From: Laura Gibbons <Laura.Gibbons@arun.gov.uk>
Sent: 07 December 2021 12:27
To: Planning.Responses <Planning.Responses@arun.gov.uk>
Cc: Simon Davis <Simon.Davis@arun.gov.uk>
Subject: RE: Planning Consultation on: Y/163/21/DOC

Engineers Comments Regarding Condition 12

Site Address: Street Buildings And Adjacent Lane North End Road Yapton BN18 0DT

Description of Works: Approval of details reserved by condition imposed under Y/13/18/PL relating to condition 12-details of implementation, maintenance and management of sustainable drainage scheme.

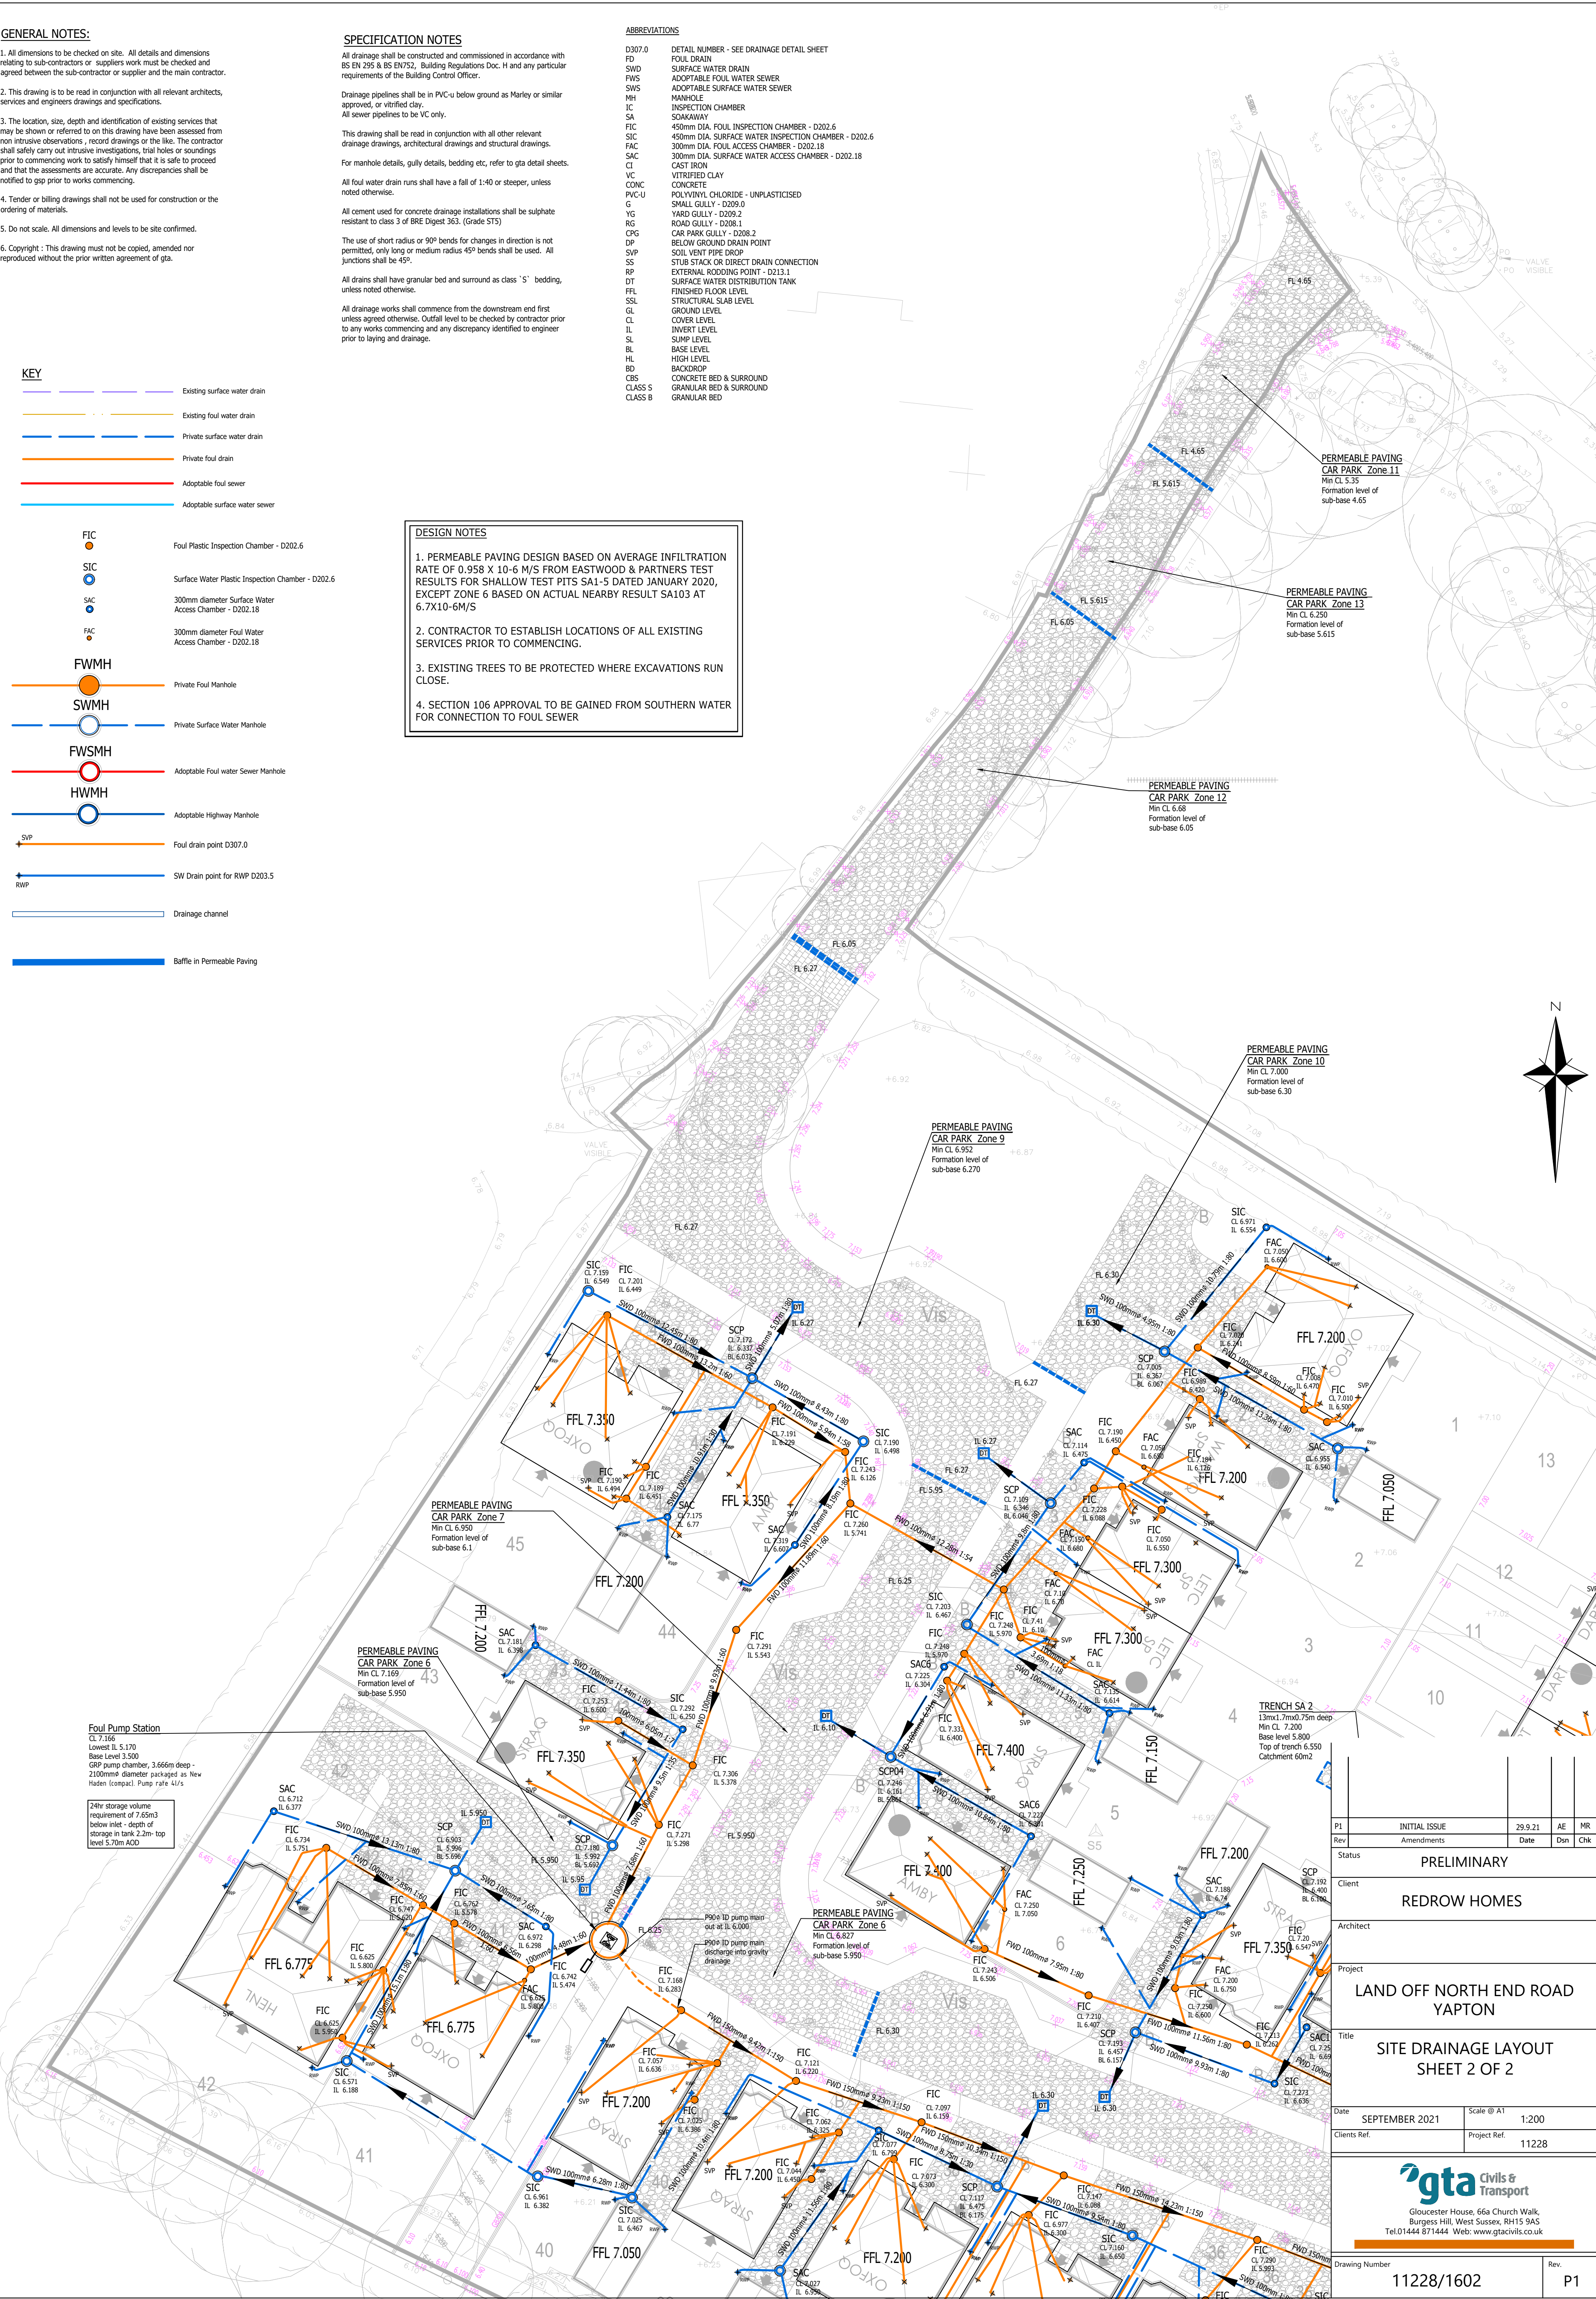
1. Construction detail drawings must be supplied.
2. Worst case infiltration rates from nearest adjacent test locations should be used in design, and not average site wide figures.
3. It is unclear if urban creep has been applied.
4. Inlets to infiltrating structures must be located above the 1 in 10 year plus 40% climate change event water levels.
5. Finish and formation levels must be labelled on plan.
6. Cap volume depths should be applied to calculations.
7. The permeable paving zone 9 area has an infiltration blanket shown in calculations, yet this is not shown on plans.
8. A safety factor of 2 has been applied to all calculations. This is not compliant with our checklist.
